**Application No:** 18/00039/DISC-2

**Proposal:** Discharge of condition 19 (materials and finishes), 23 (bus stops), 59 (Construction Management Travel Plan) of 10/01780/HYBRID.

**Location:** Bicester Eco Town, Exemplar Site, Banbury Road, Bicester.

## **Transport Development Control**

Title: SPINE ROAD (S38) GENERAL ARRANGEMENT SHEET 1 OF 4

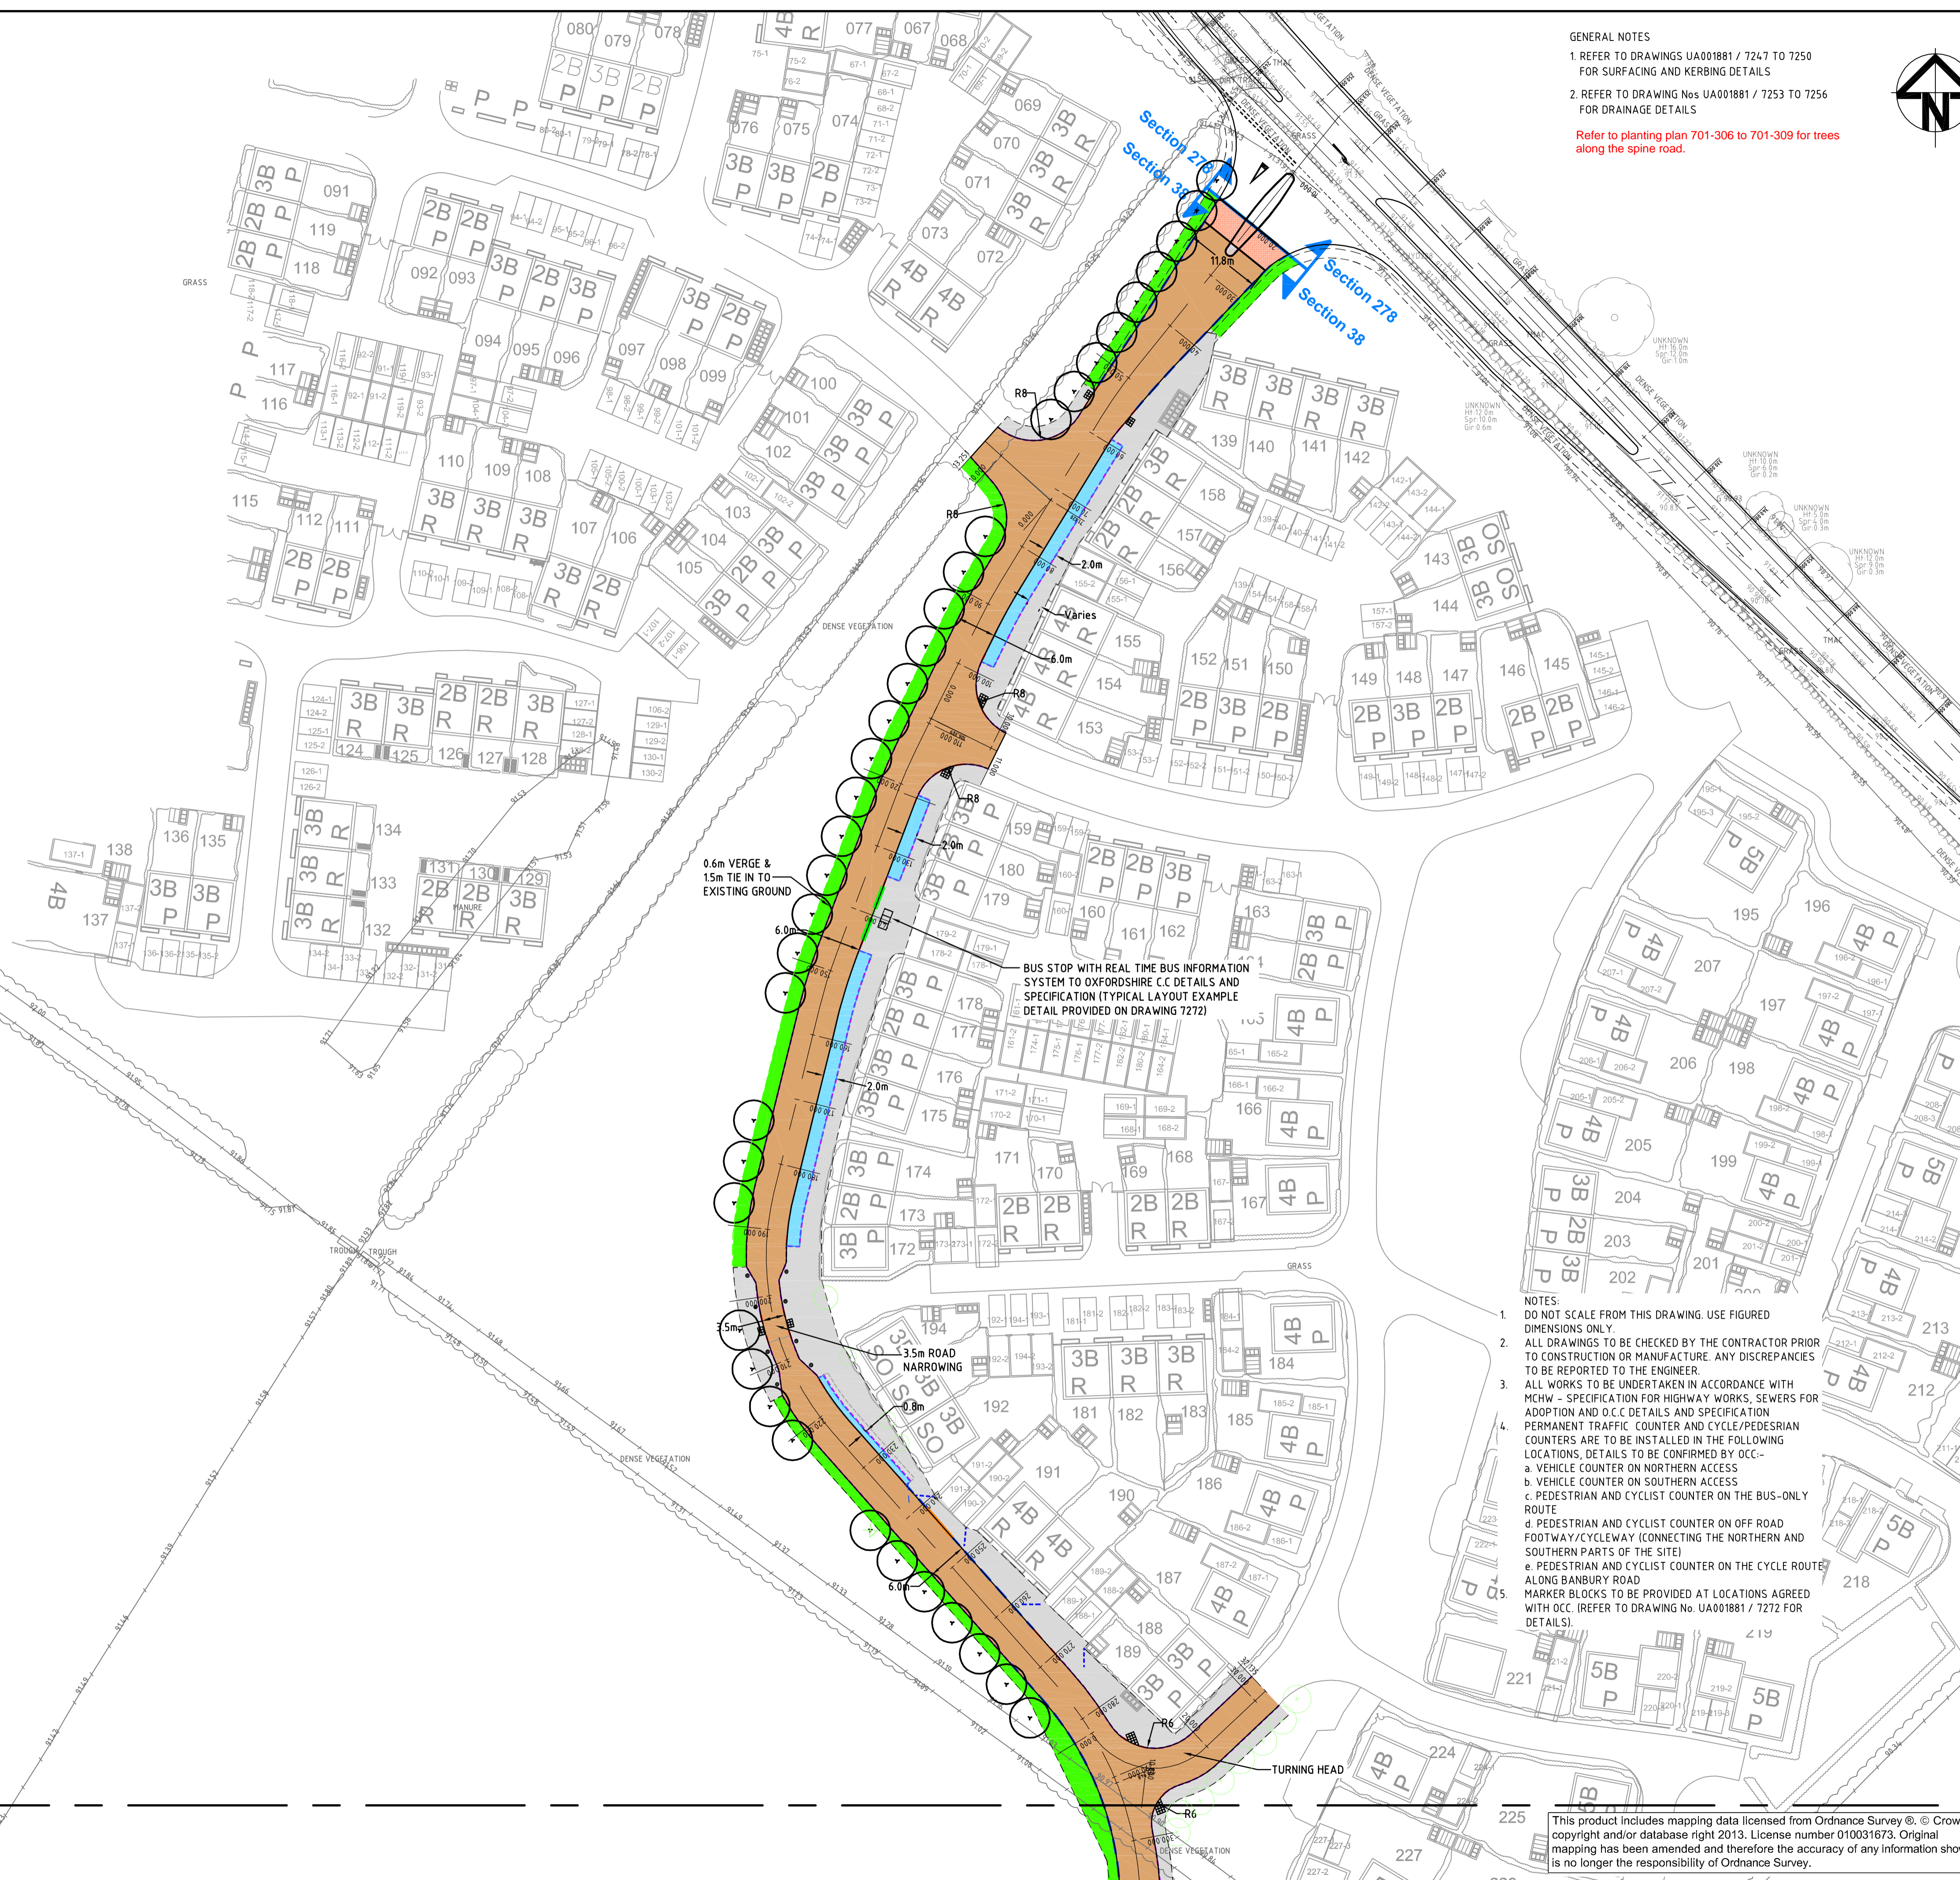
- Condition 23 still requires the applicant to agree to the shelter type designs and maintenance plans.
- A CTMP should be updated to cover pertinent issues that were highlighted within the HA's response for Condition 59 to be discharged.
